From: Jean Fraser
To: Federle, Tom
CC: Thompson, Jennifer
Date: 4/9/2014 4:03 PM
Subject: Re: 118 condo documents- City comments

From: Jean Fraser <JF@portlandmaine.gov>
Date: Monday, April 7, 2014 10:59 AM
To: Tom Federle <tom@federlemahoney.com>
Cc: 'Ed Theriault' <etheriault@e-tla.com>, <chip@newheightgroup.com>
Subject: 118 condo documents- City comments

I refer to the ""Public Offering Statement" and various sections and exhibits that you sent to us on March 26, 2014. These are generally fine but we have a couple of comments from the Associate Corporation Counsel:

A2.01

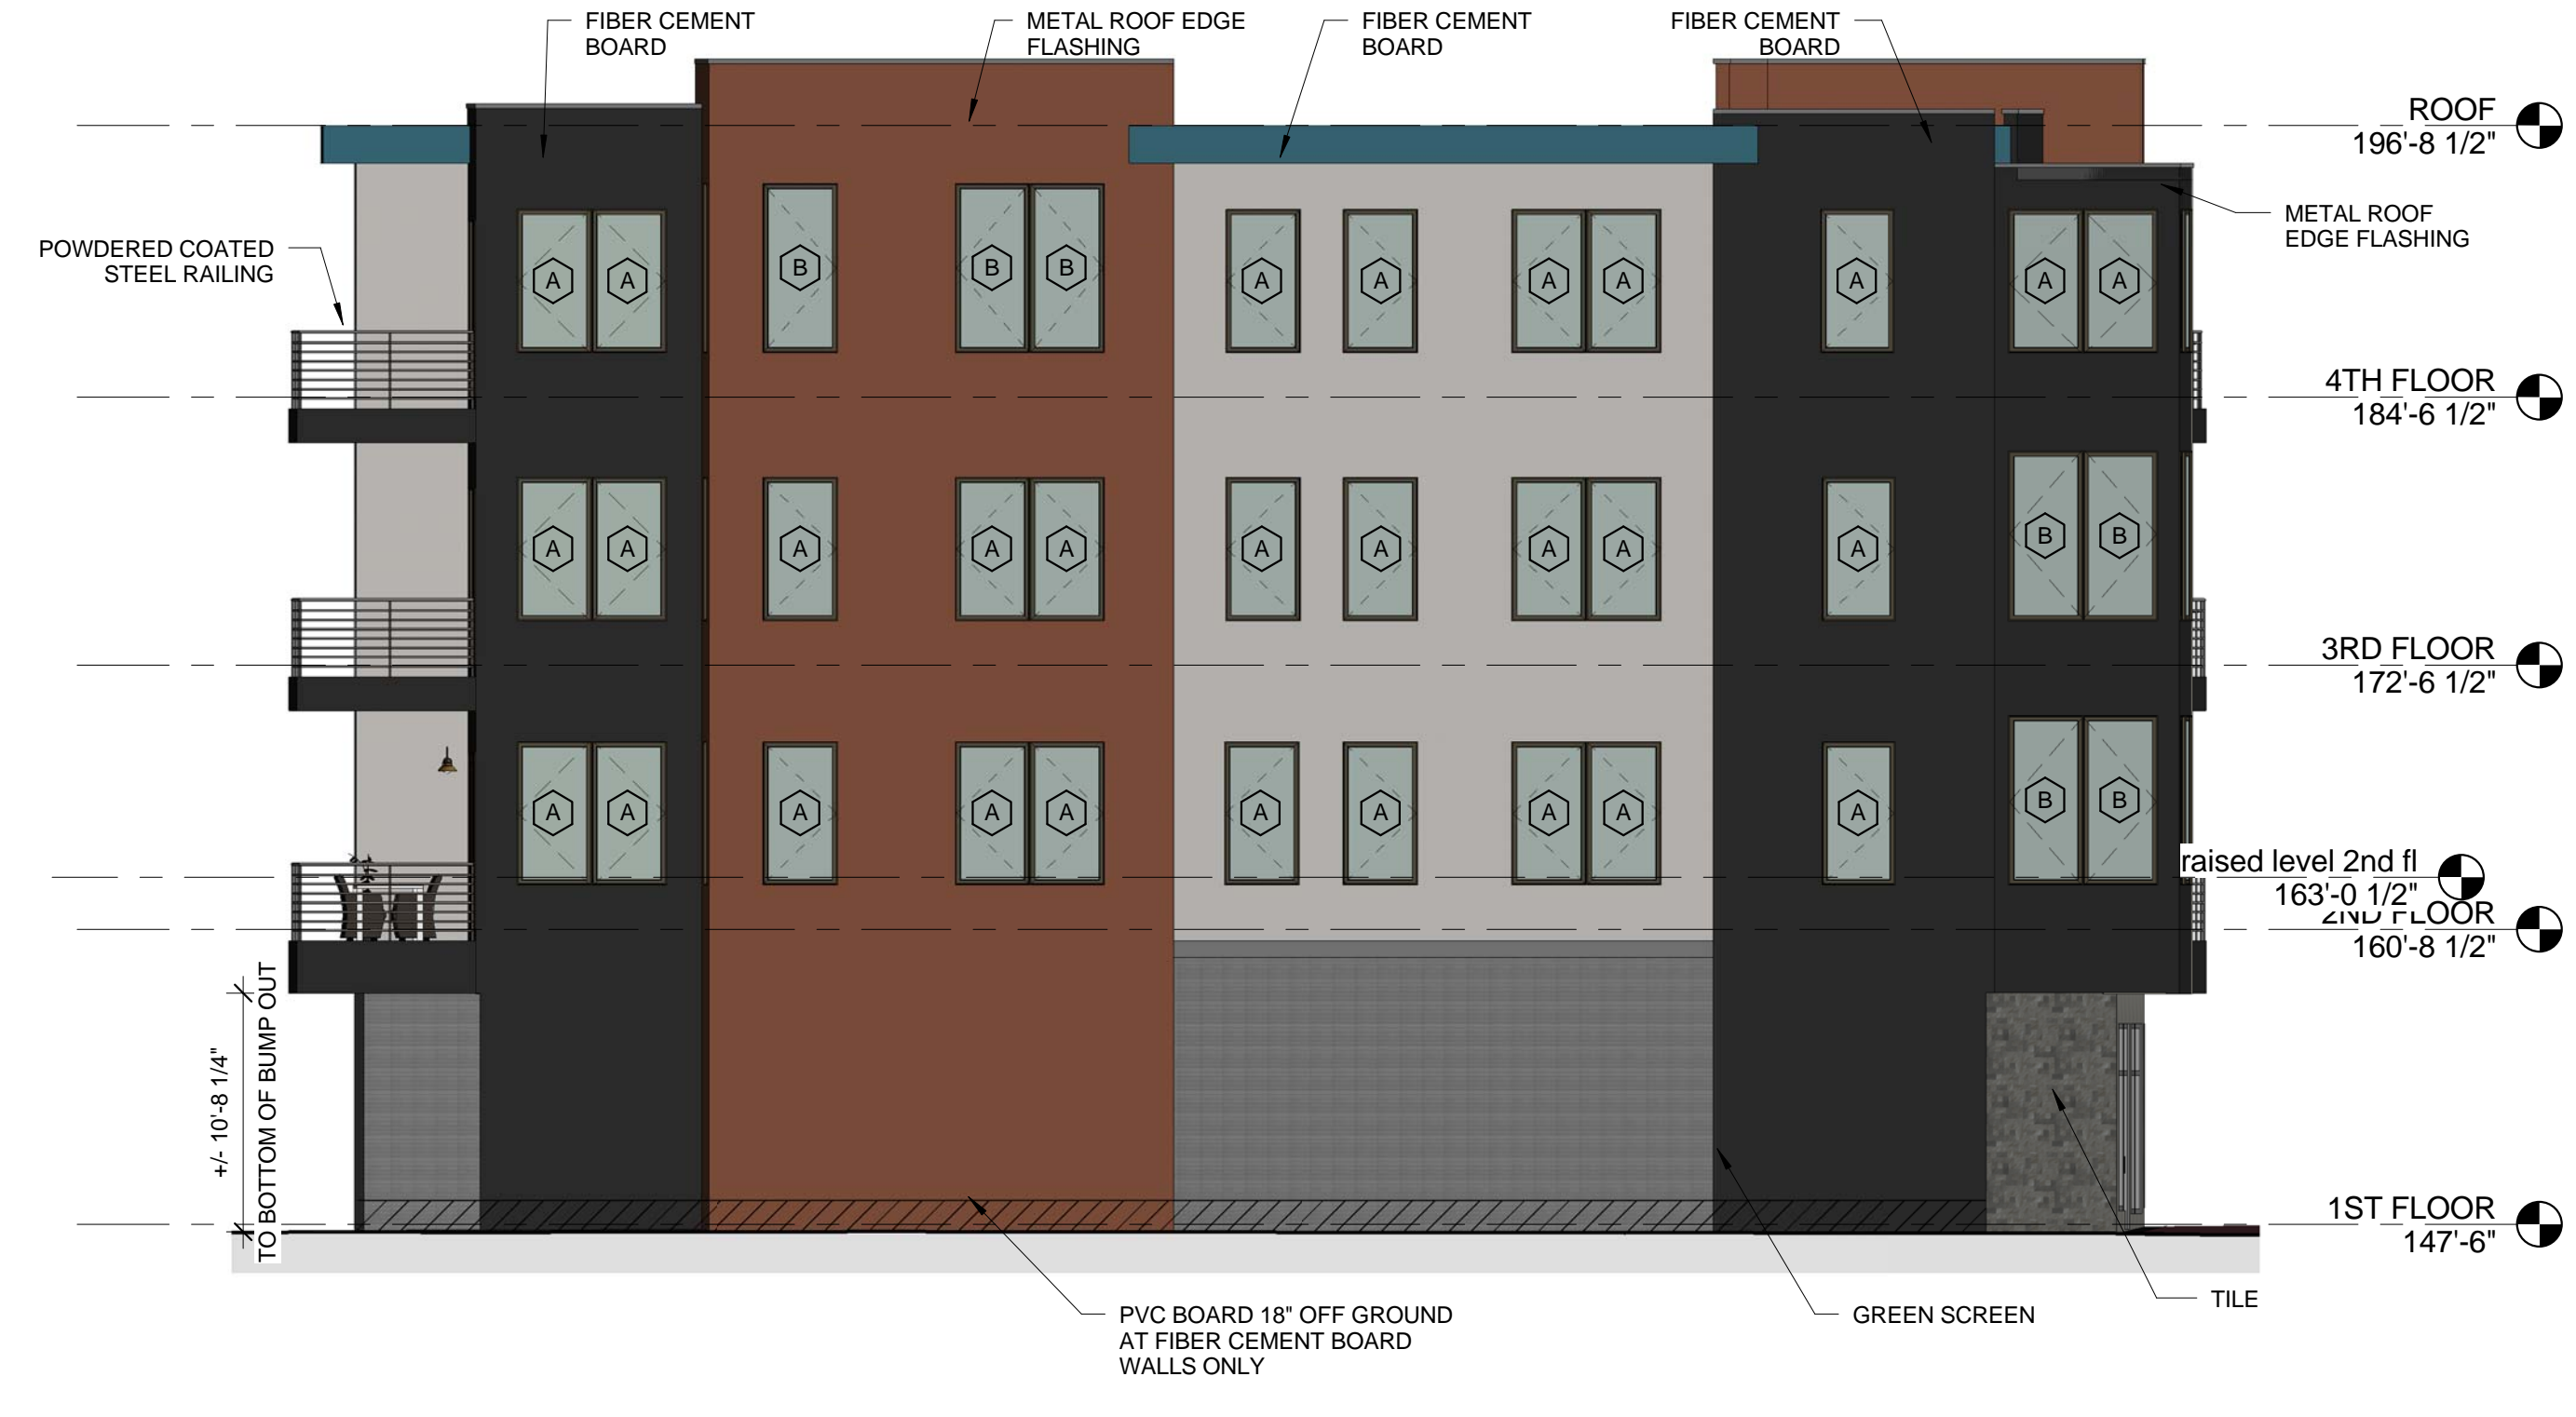
I was wondering who is responsible for the lights on the front of the commercial units, particularly the ones that are the subject of the last condition of approval:

i. That the two adjustable "flood" lights on the front of the building over the commercial unit windows shall be adjusted in accordance with the City's Technical Standard 12 "Site Lighting" Section 12.4.

These lights do not appear to be included in 11A ii and I would like to have the condition added in to the Condo Declaration where-ever these lights are mentioned- as presumably it is a restriction on the lights and needs to be on the record for future owners.

PUBLIC OFFERING STATEMENT
118 ON MUNJOY HILL, A CONDOMINIUM
EXHIBIT A
SUBDIVISION OF PLAT APPROVED 1/28/14

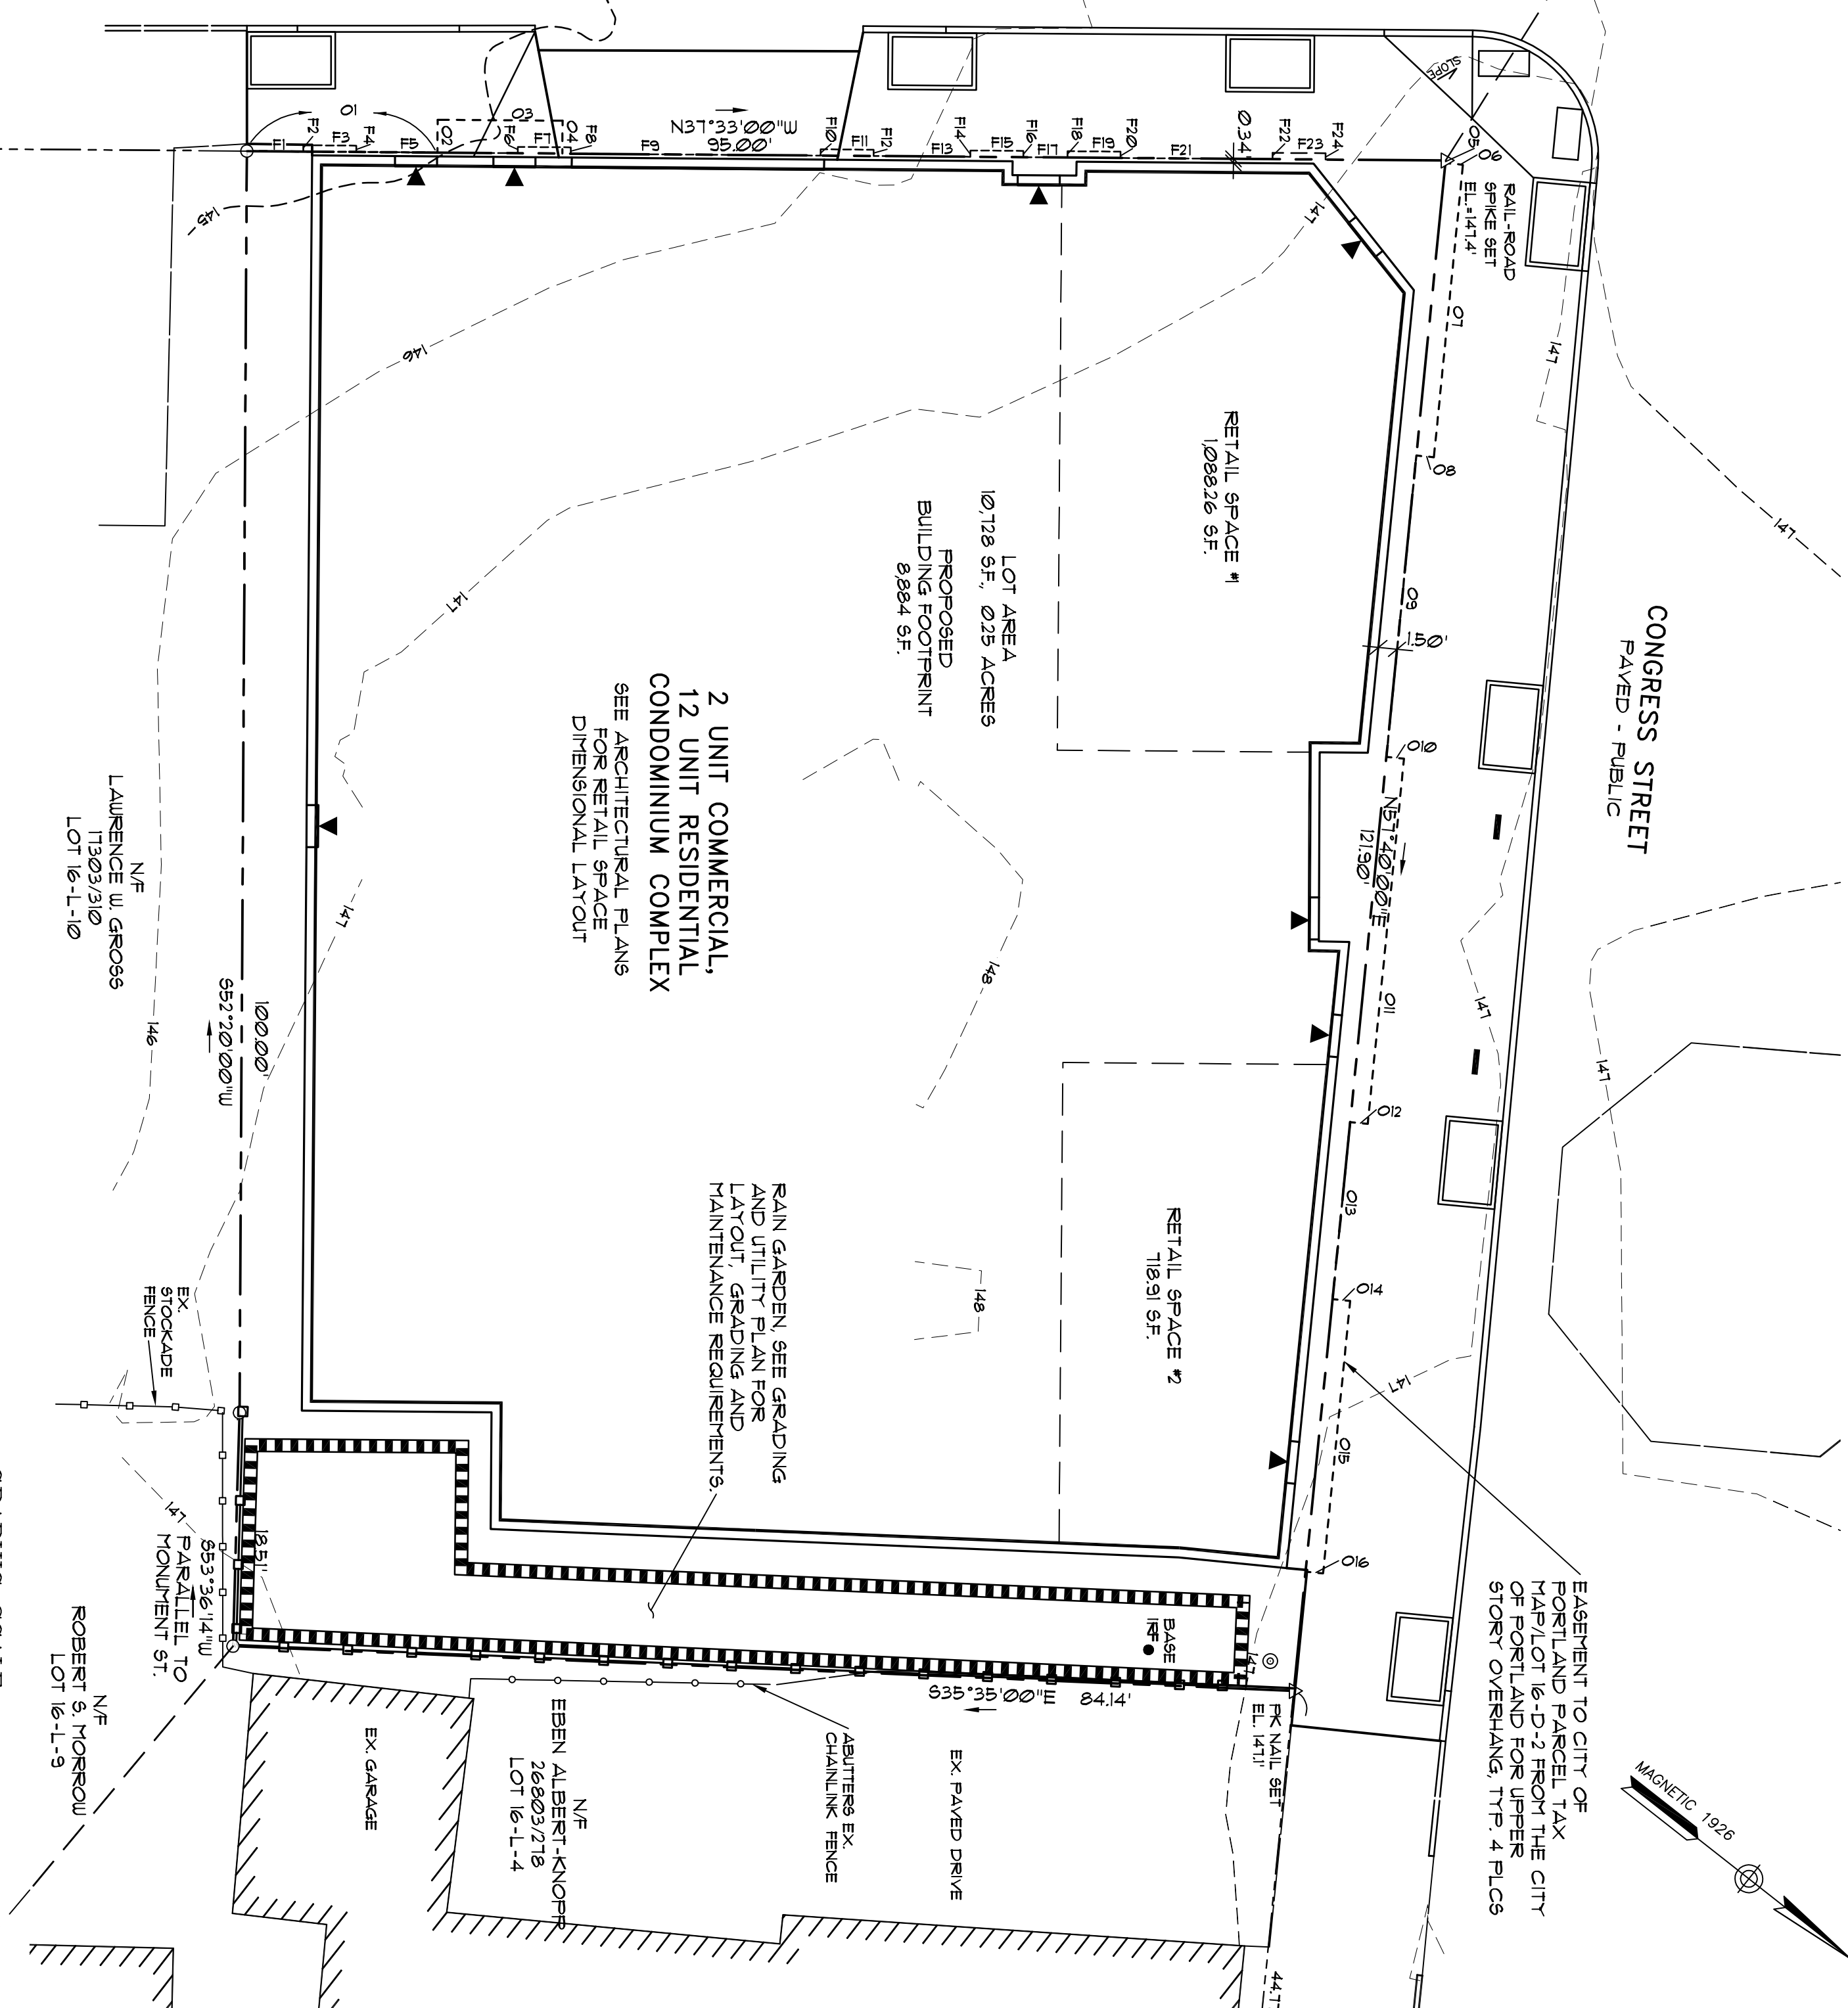
Exhibit A: PI note earlier comment that this Subdivision Plat is a draft and should not be labelled as 'approved'. We have a number of substantive comments on the draft Plat which will be forwarded later today to Tom Greer.
